Your ref: SSD 6767
File no: MC-14-02158

**Re: SSD 6767 Proposed Liquid Waste Treatment Facility at Lot 123 DP
870988, 14 Rayben Street, Glendenning**

ATTACHMENT A

20kL
NON-COMPLIANT
PRODUCT TANK

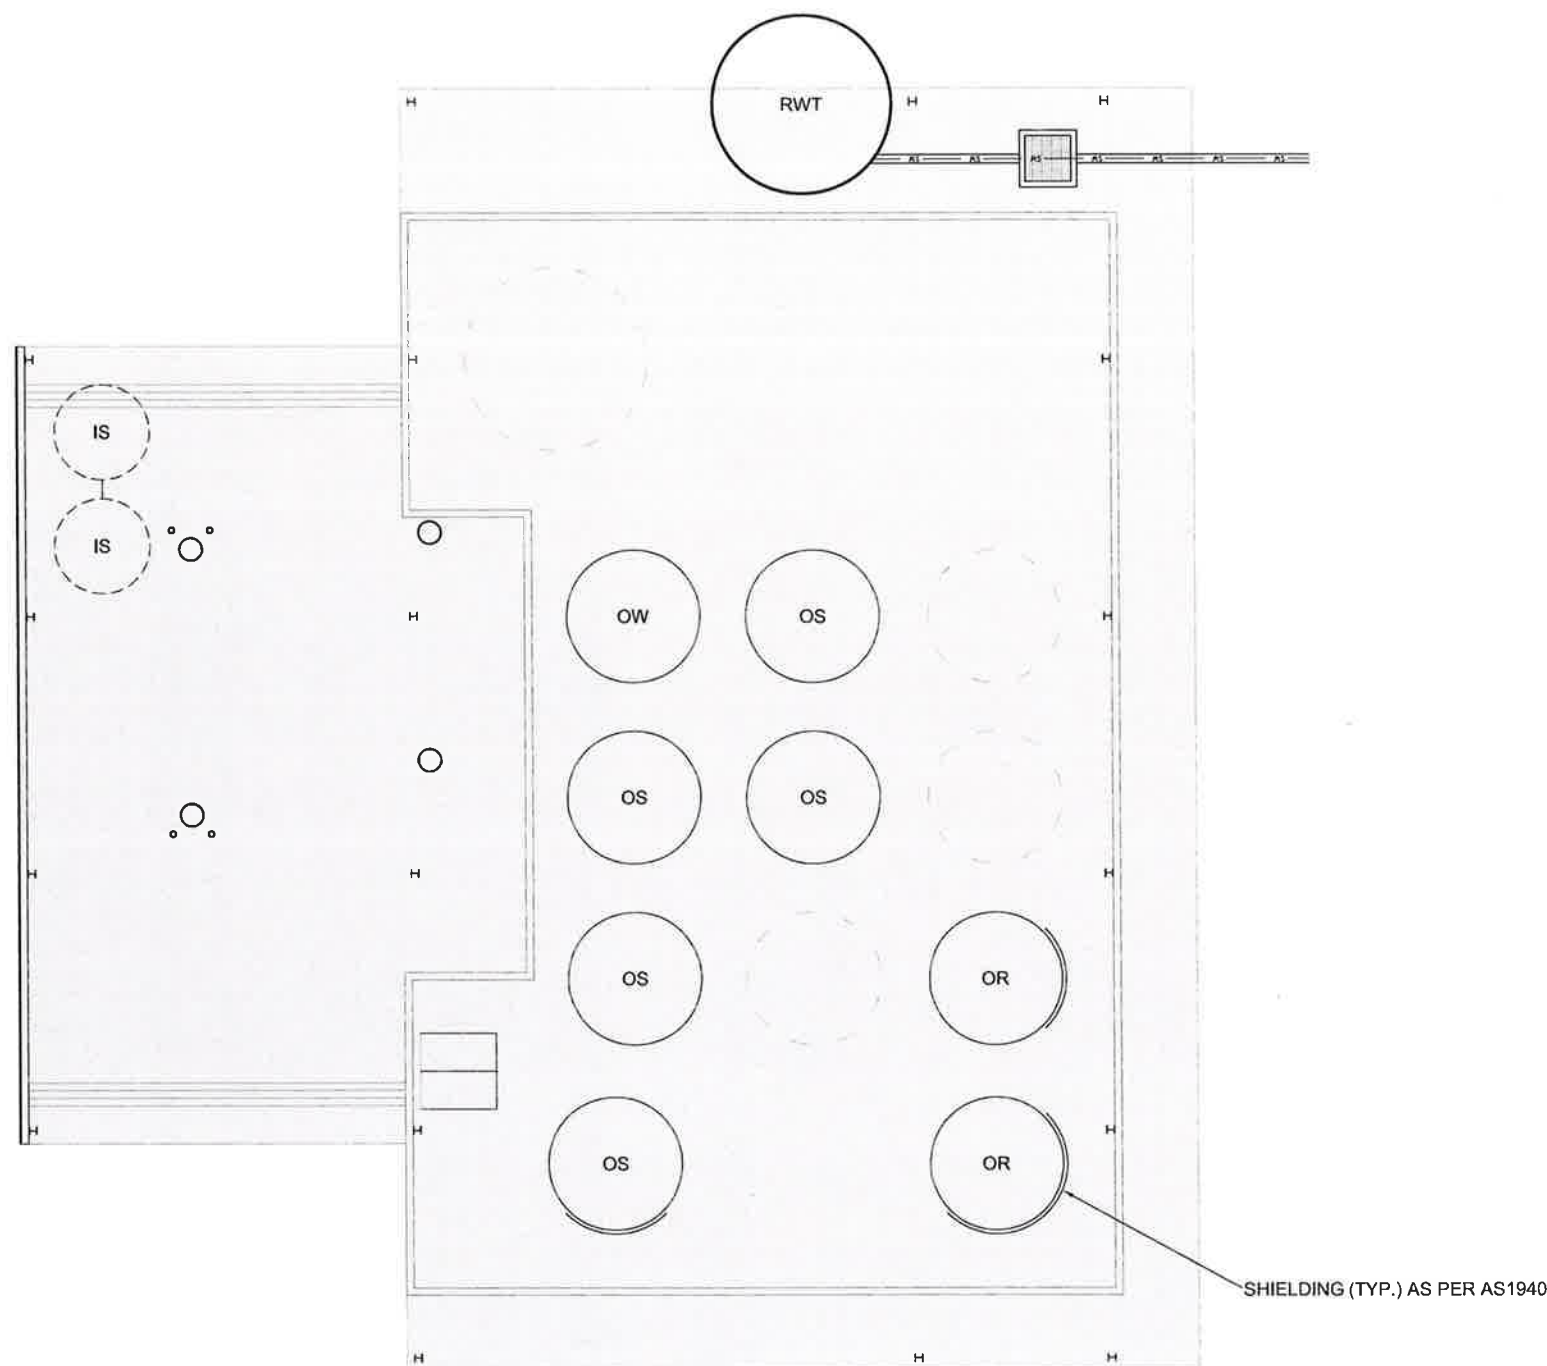
6. The EIS identifies that if preliminary assessments and samples are taken and used oil does not meet the acceptance criteria, that it is unloaded to the 20kL non-compliant product tank. However, the EIS also identifies that all waste is evaluated prior to collection to avoid such an occurrence.

Please confirm the process to evaluate non-compliant oil is capable of identifying non-compliant oil, and also confirm the potential for such oil to be transferred to an alternate facility as opposed to be stored on-site.
